WEST SUSSEX COUNTY COUNCIL CONSULTATION

TO:	Arun District Council FAO: Stuart Corbey
FROM:	WSCC - Highways Authority
DATE:	10 April 2019
LOCATION:	33 Shelley Road, Bognor Regis, PO21 2SN
SUBJECT:	BR/76/19/PL Conversion of existing house into 2 No. 3 bed semi detached properties.
DATE OF SITE VISIT:	N/A
RECOMMENDATION:	Advice
S106 CONTRIBUTION TOTAL:	£N/A

Proposed Conversion Proposed Plans Planning
Date March 2019
Scale 1:50

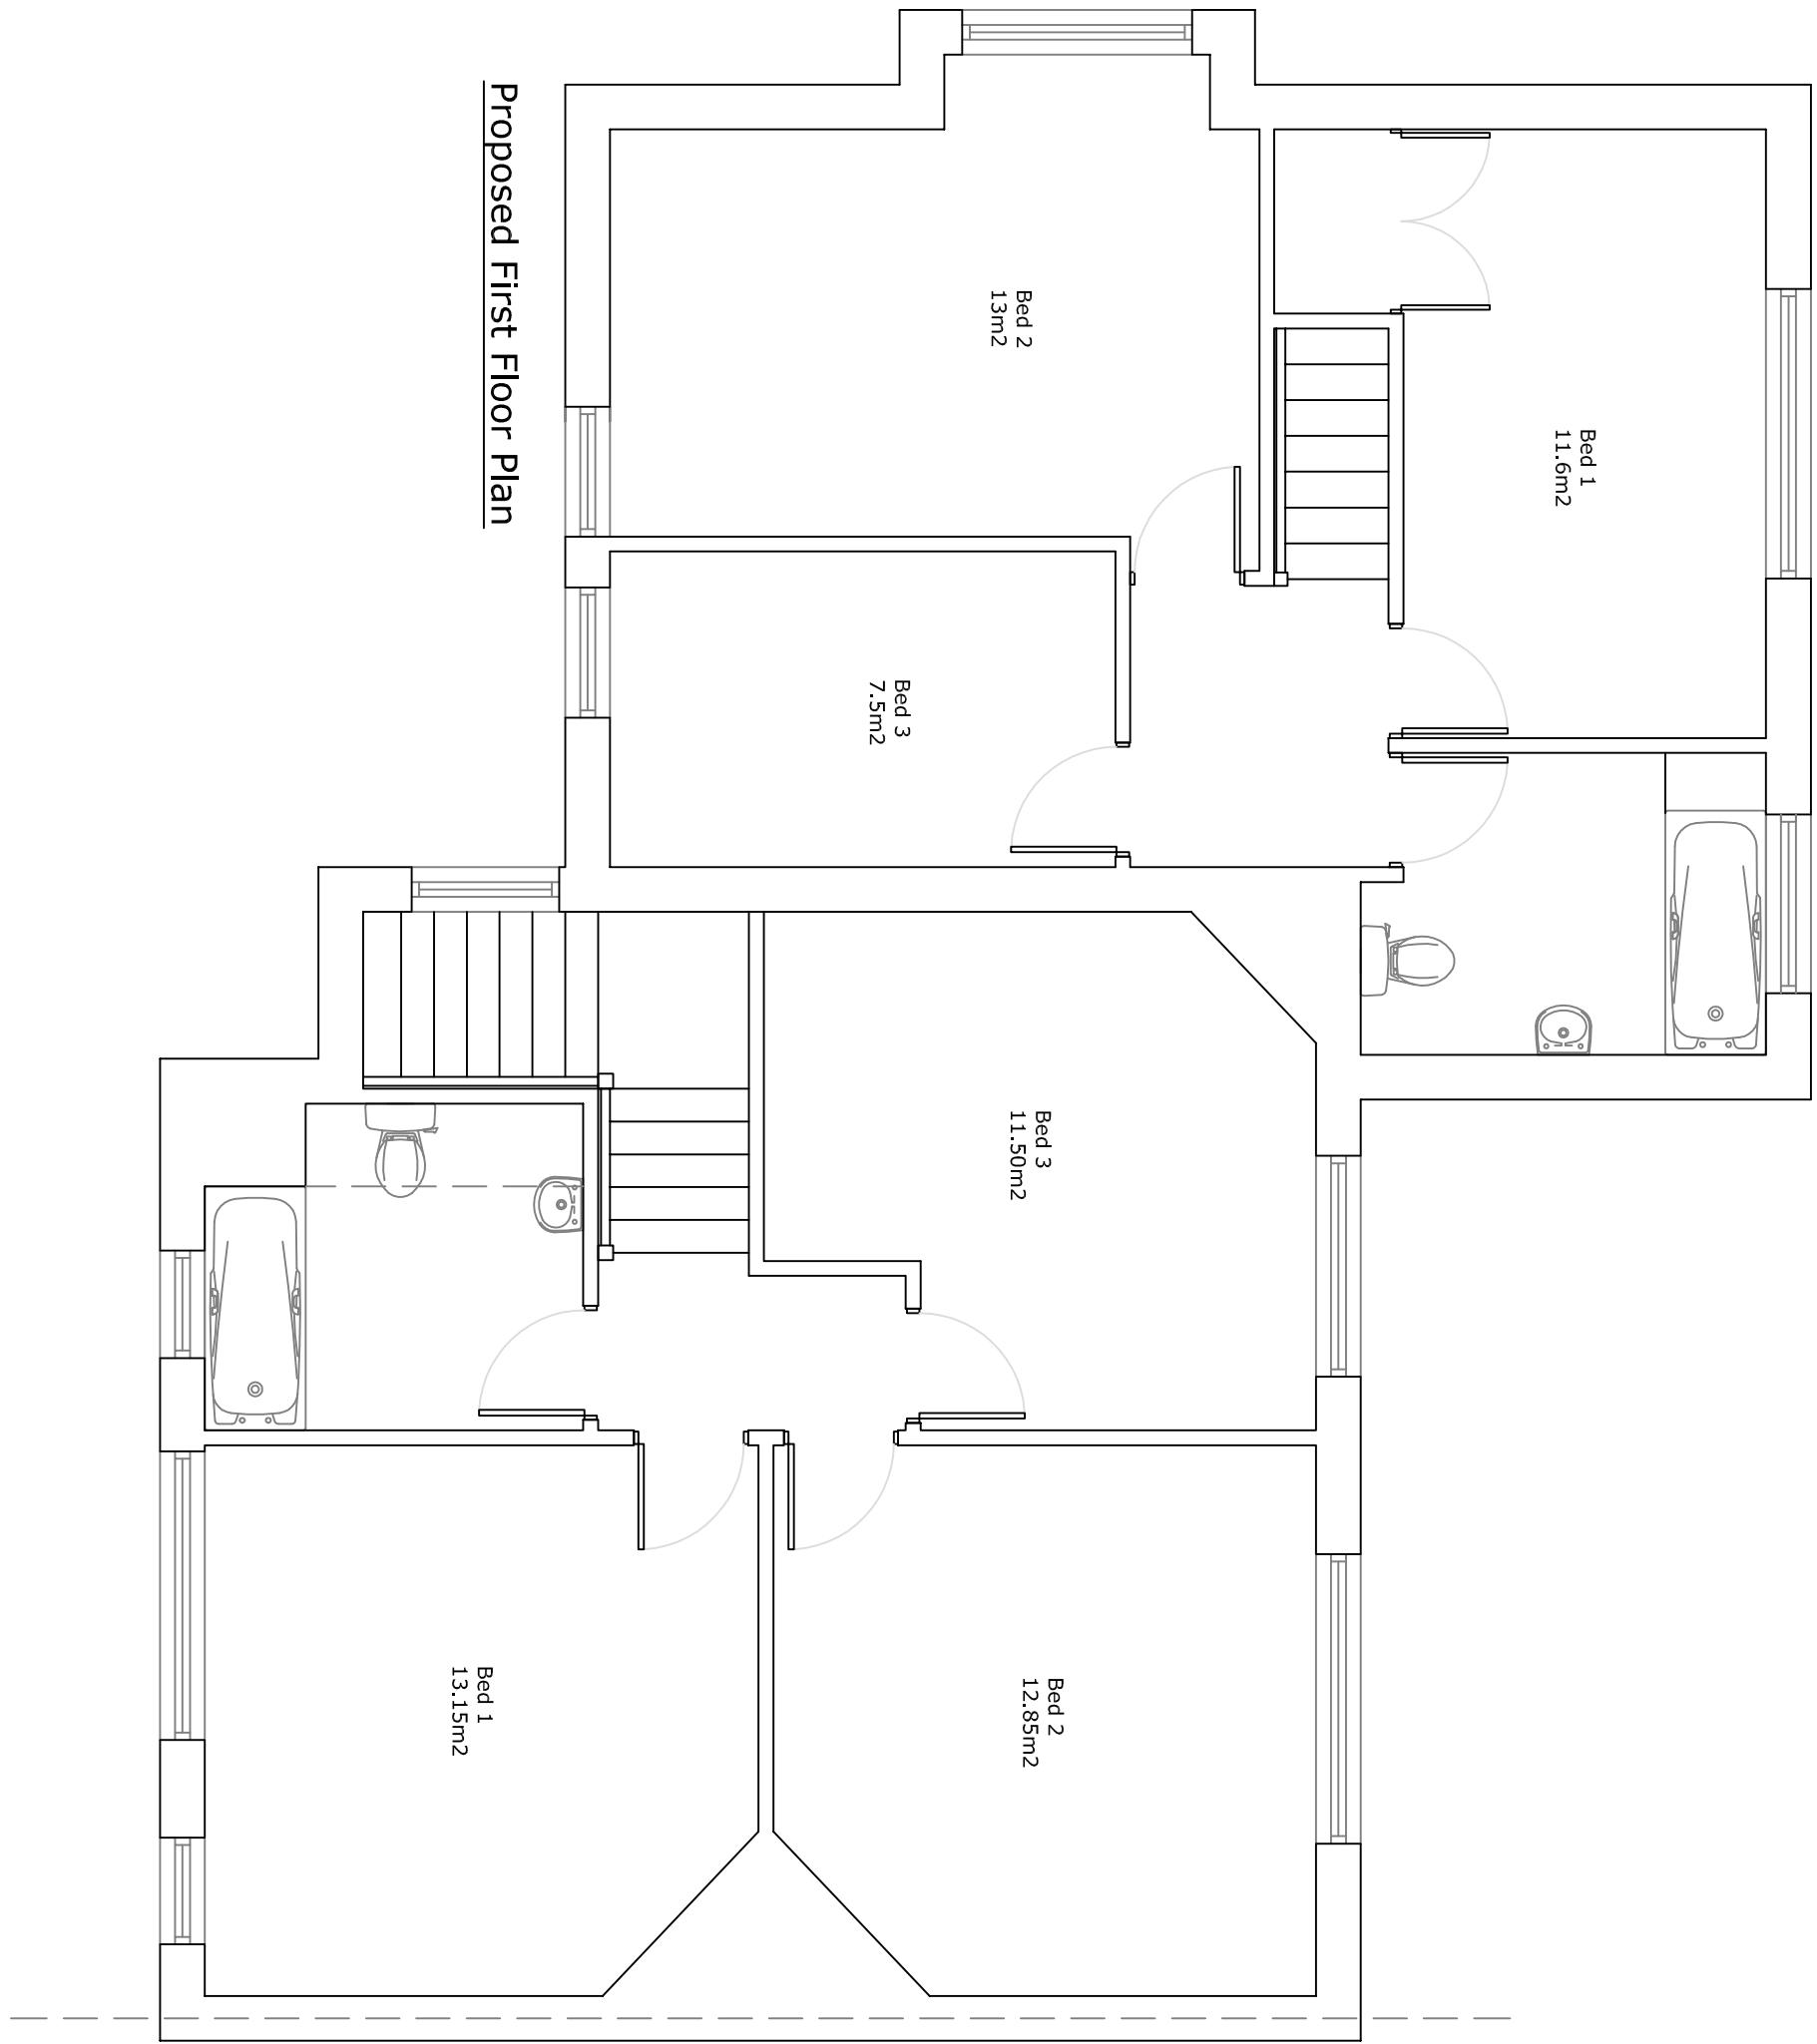
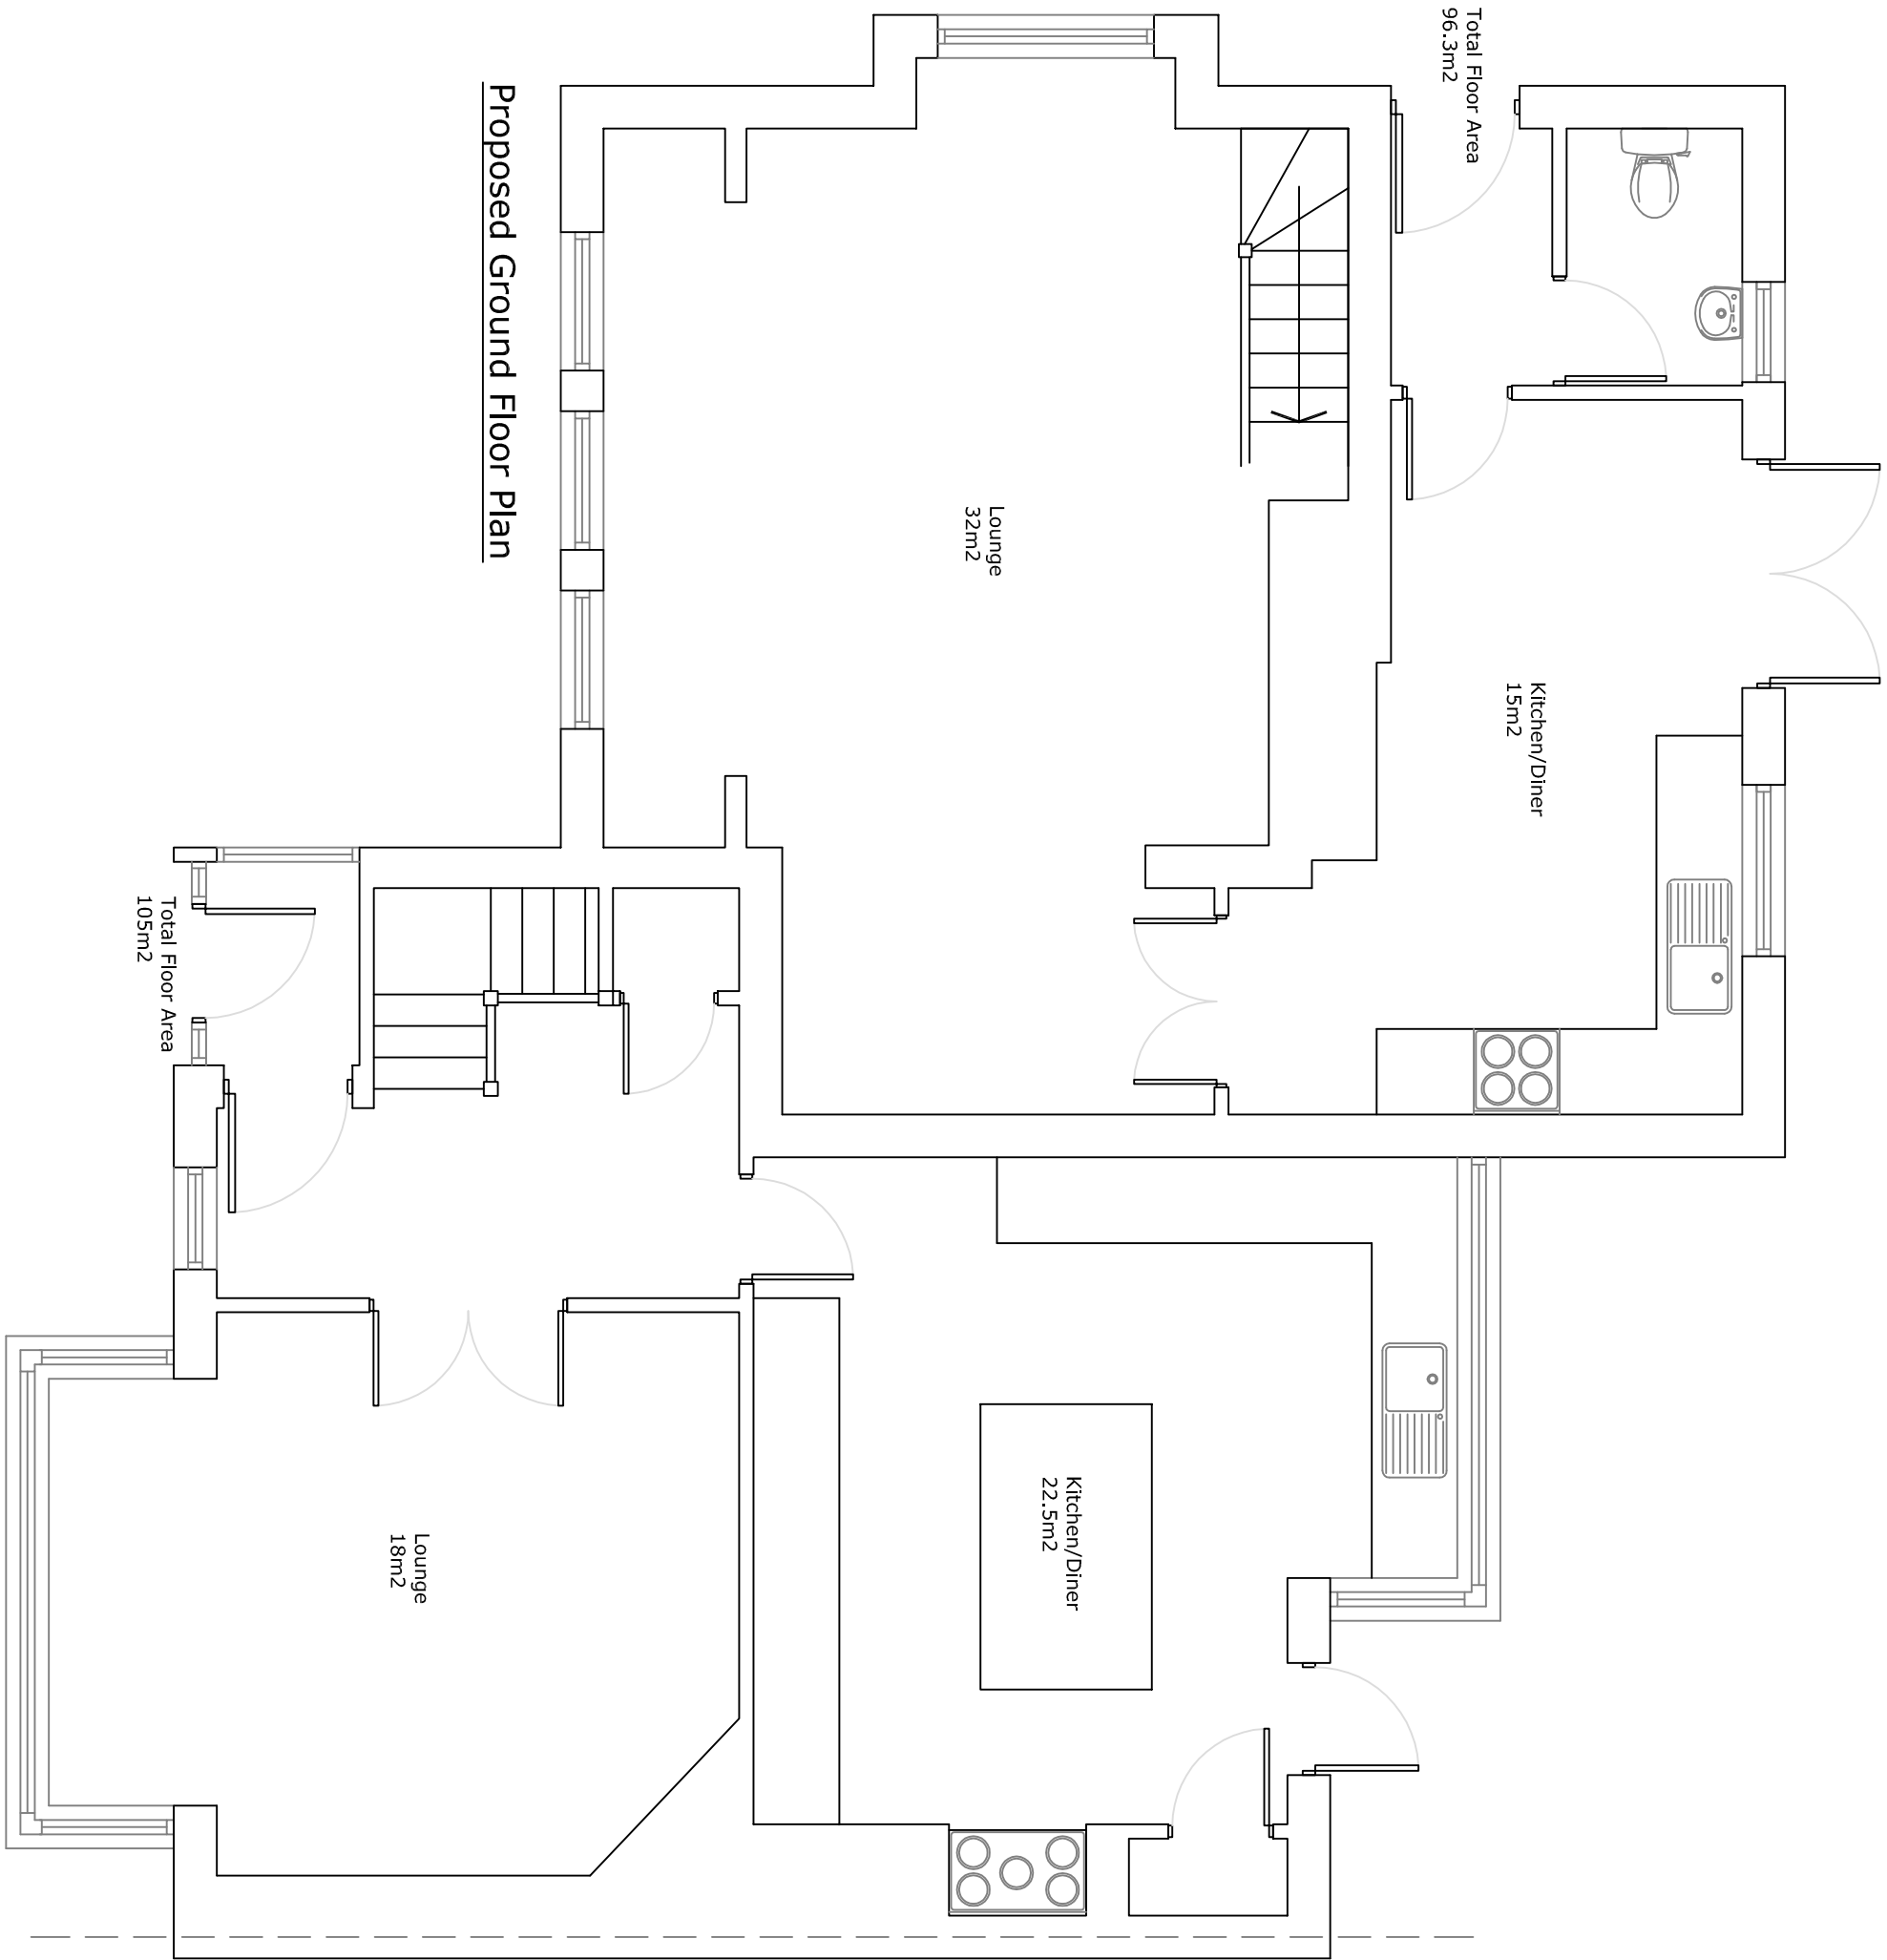
4 car parking spaces are proposed for the development, 2 for each of the proposed properties. There is sufficient room for 4 cars to park at this property. Using the WSCC Car Parking Demand Calculator, it has indicated that a property of this size in this location would create a demand of 5 car parking spaces. As 4 spaces are provided, any overspill parking would have to be accommodated on-street. The Local Highway Authority (LHA) would not consider this detrimental to highway safety, but the LPA may wish to consider the potential impacts of this development on on-street parking from an amenity point of view.

The property is situated in a sustainable location, with shops and services located nearby down Aldwick Road. Regular bus routes pass through Aldwick road, connecting the area to Bognor Regis Town Centre and other nearby towns. The local primary school is also within walking distance. Cycling is a viable option in the area. To improve the sustainability of the development, it is recommended that secure and covered cycle storage is included in the plans, to offer alternative transport options and reduce the need to travel by private car.

No part of the development shall be first occupied until covered and secure cycle parking spaces have been provided in accordance with the approved plan.

No part of the development shall be first occupied until the car parking has been constructed in accordance with the approved site plan. These spaces shall thereafter be retained at all times for their designated purpose.
